Application for Planning Permission for Works or Extension to a Dwelling

Development: Erection of part single, part two storey rear extension with juliette balcony and installation of front window.

Location: 8 Ferring Grange Gardens Ferring BN12 5HS

Block Plan
Scale: 1:500

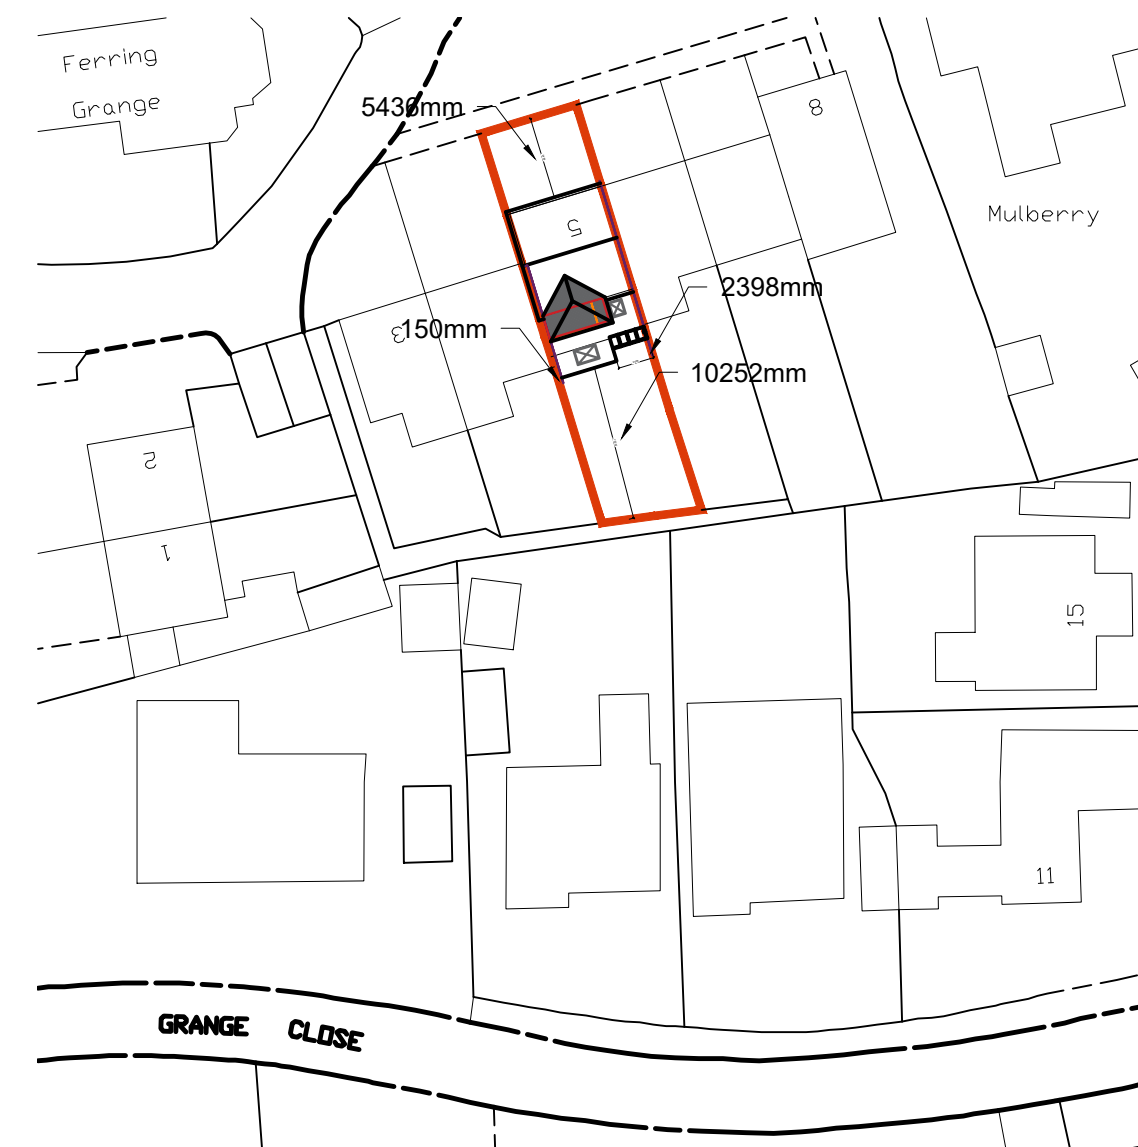
You are required to have dimensions from the proposed extension(s) to all site boundaries. Please amend.
